## Department of Primary Industries

OUT16/17401

### **Parkes Solar Farm Project (SSD 6784) Comment on the Environmental Impact Statement**

PROPOSED INFRASTRUCTURE

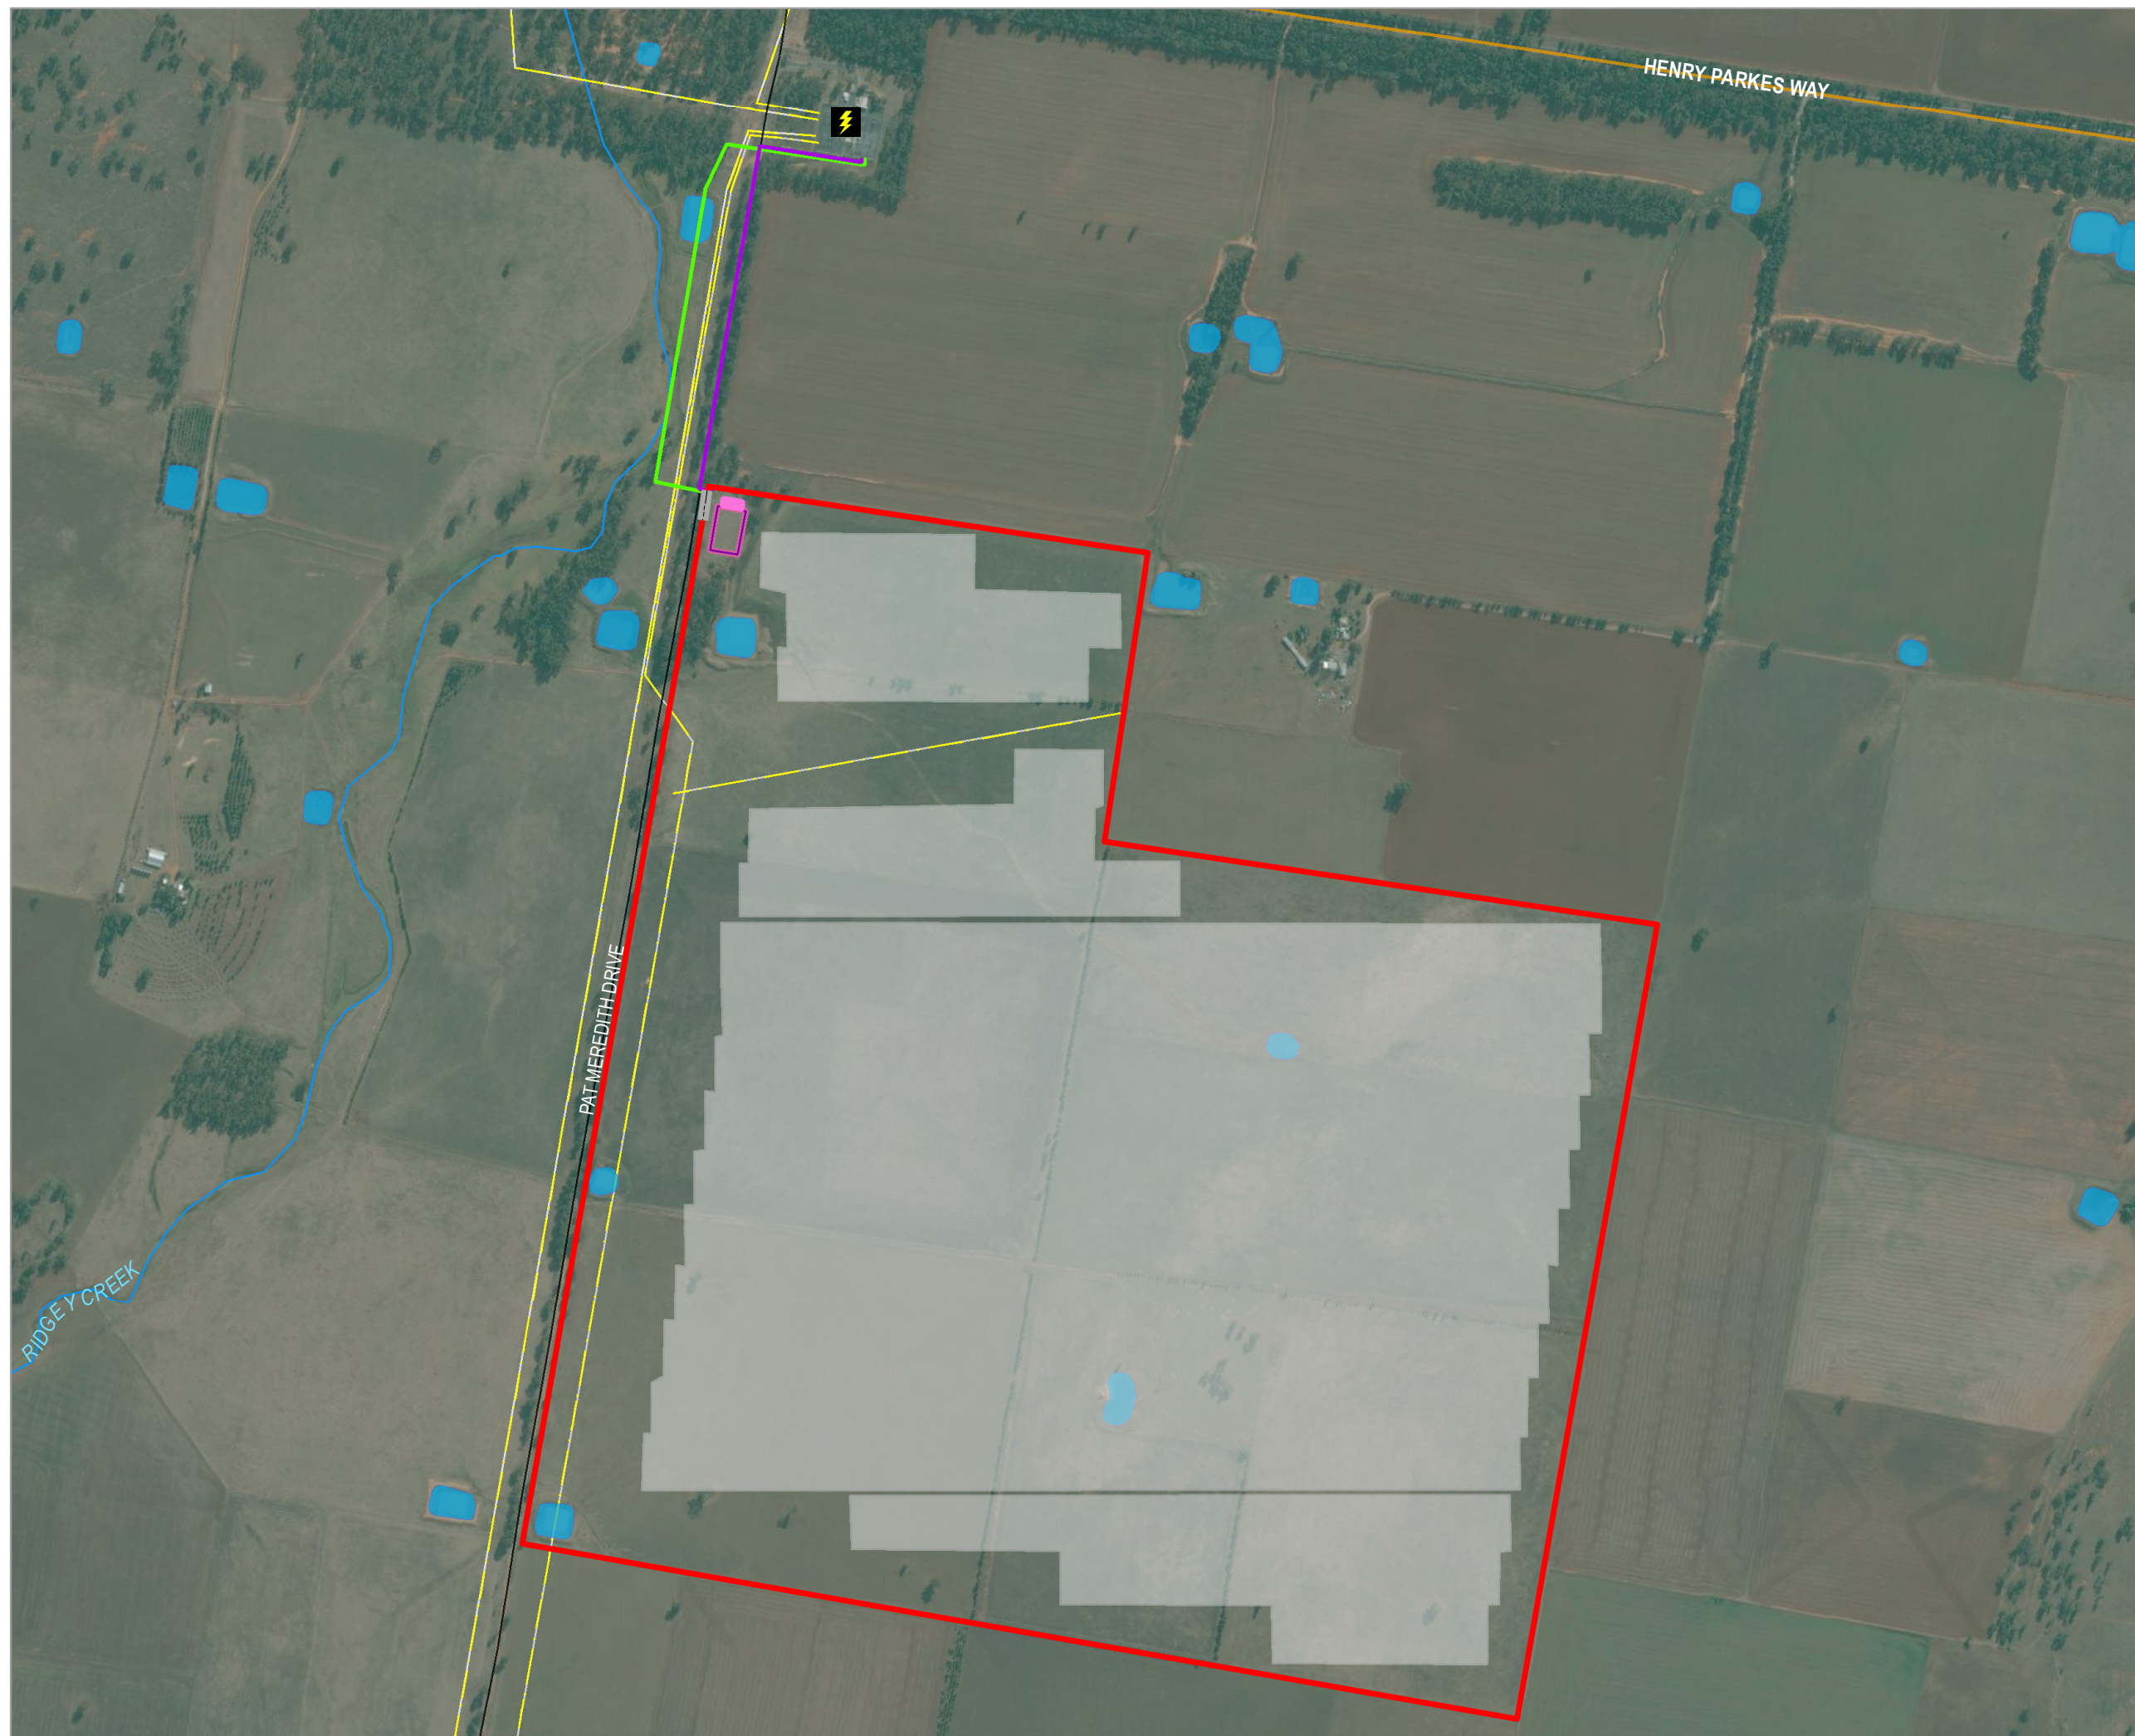
- Two groundwater bores are located within the footprint of the proposed solar array infrastructure. Any proposed changes to the bore infrastructure (eg. decommissioning)

will require consultation with DPI Water to confirm requirements under the *Water Management Act 2000* and relevant standards to complete the works. The use of water from these bores would require the proponent to acquire sufficient entitlement in the relevant water source and may require additional approvals under the *Water Management Act 2000* if not considered within the current SSD project.

- Two dams are located within the footprint of the solar infrastructure and there is a minor drainage line connecting dams on the property. Modifications to these dams and consideration of alterations to drainage paths due to the proposed infrastructure (eg. roads, solar infrastructure, trenching) will need to be addressed in development of relevant management plans for the site. The proposed above ground transmission line is proposed within 40m of Ridgely Creek, however the extent of works is uncertain. It is recommended works within waterfront land be consistent with DPI Water's "Guidelines for Controlled Activities on Waterfront Land (DPI 2012)".
